14 December 2018

Reference: F6 Extension Stage 1 – SSI 8931

Thank you for the opportunity to review and comment on the Environmental Impact Statement for the proposed F6 Extension Stage 1 Project. The following are our comments.

Figure 2-6 Stormwater drainage concept at President Avenue

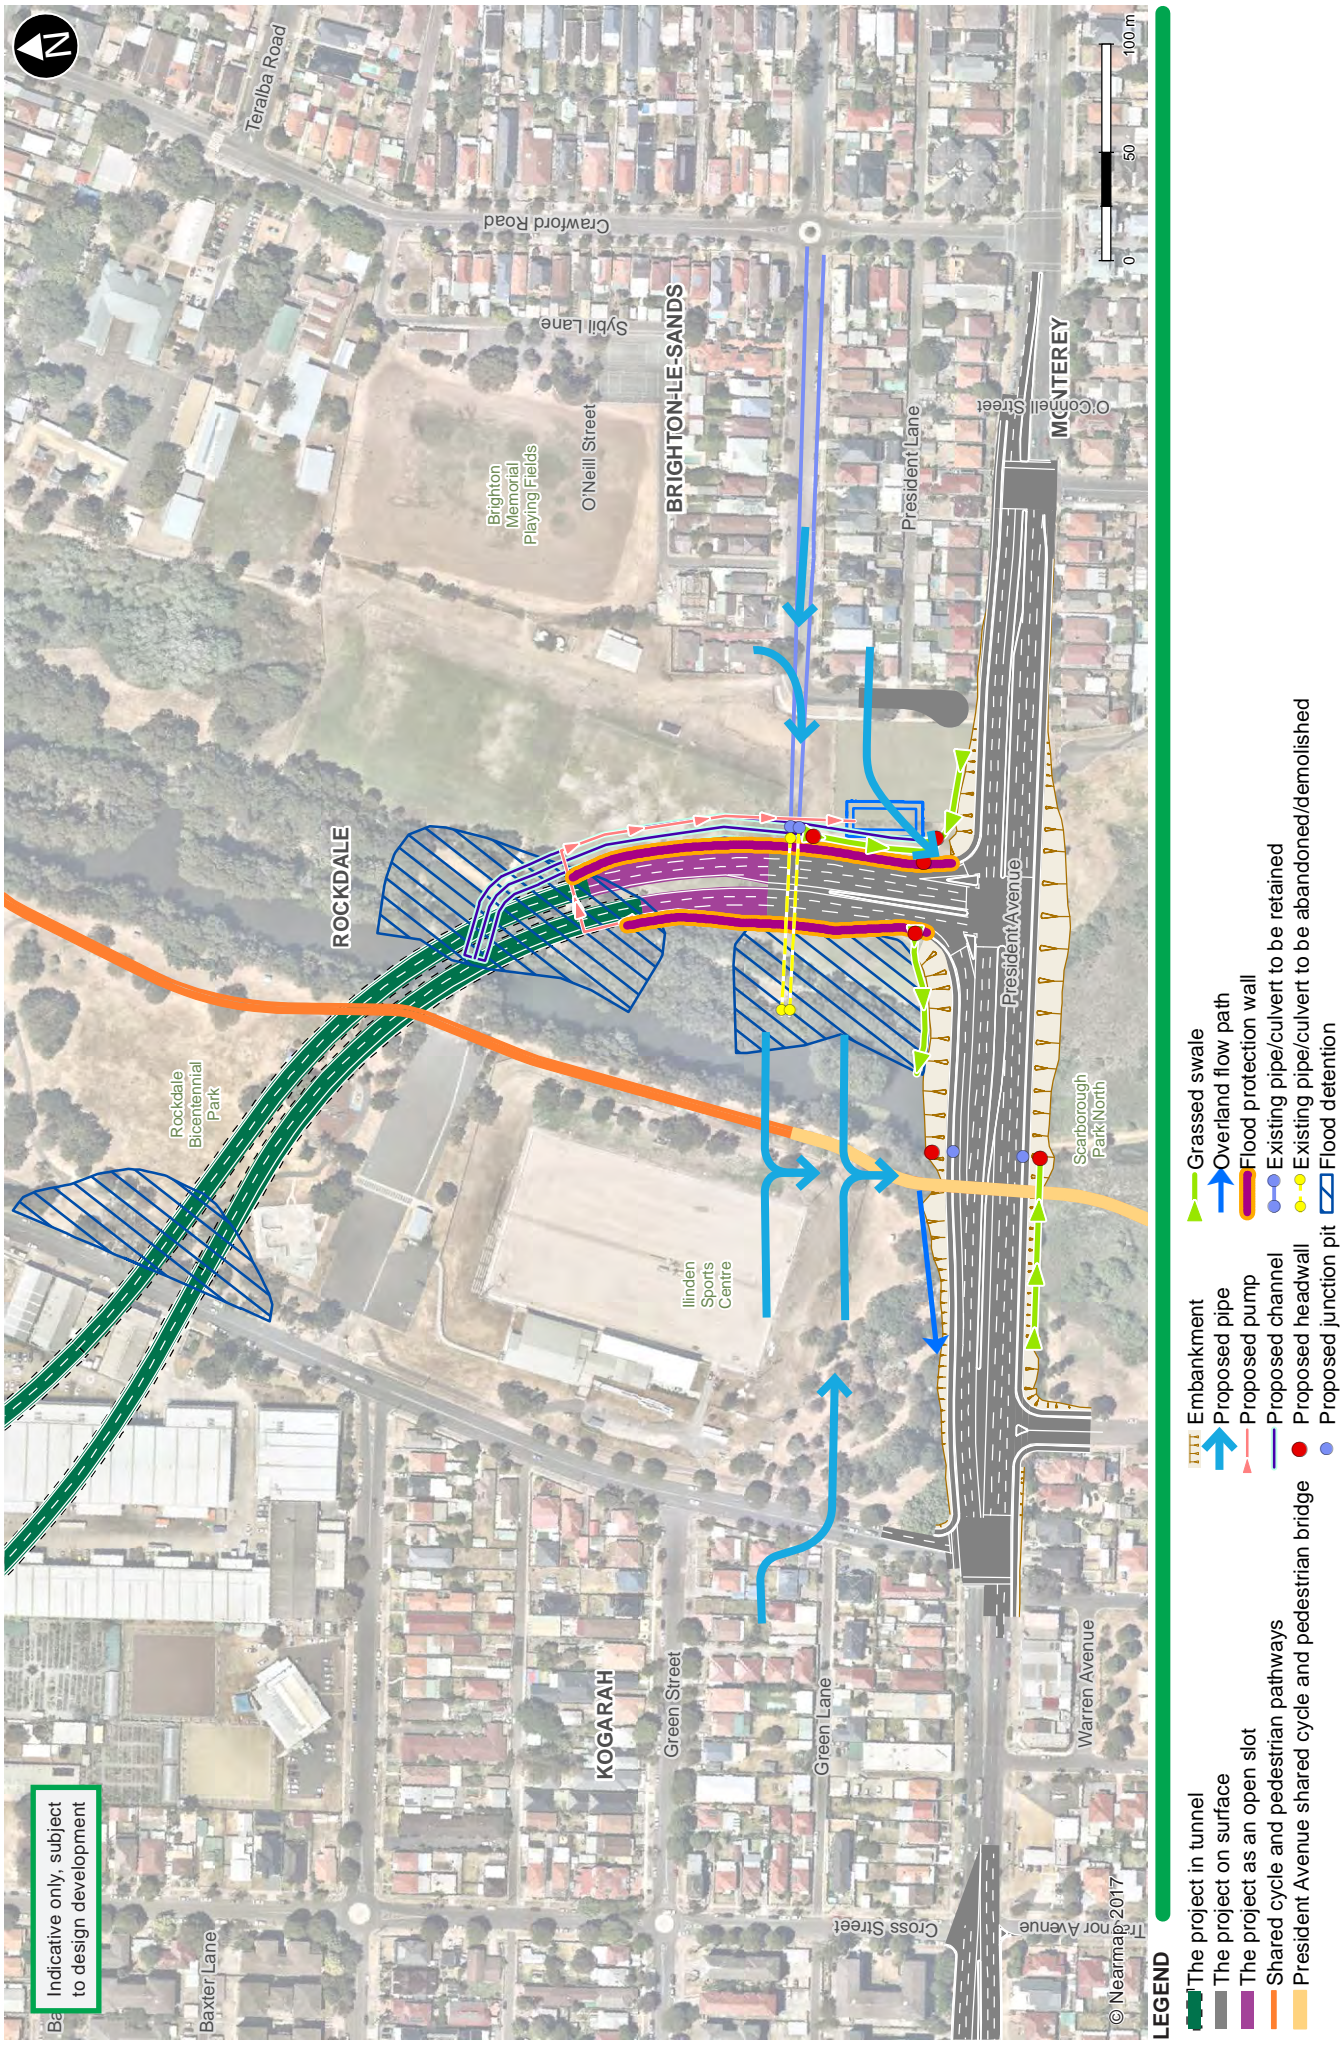
- Out of catchment offset stormwater treatment strategies are not appropriate and are not supported. The project should directly manage and treat stormwater runoff from its own pavement areas.

It is not appropriate to take the 'low-hanging-fruit' from areas outside project drainage system to facilitate a disregard of stormwater water quality discharges from the project pavement areas.

- Given the anticipated adverse impact to groundwater the project designers should reconsider the stormwater strategy and seek to comply with the Council stormwater retention strategy for development and develop a groundwater recharge approach for stormwater disposal.
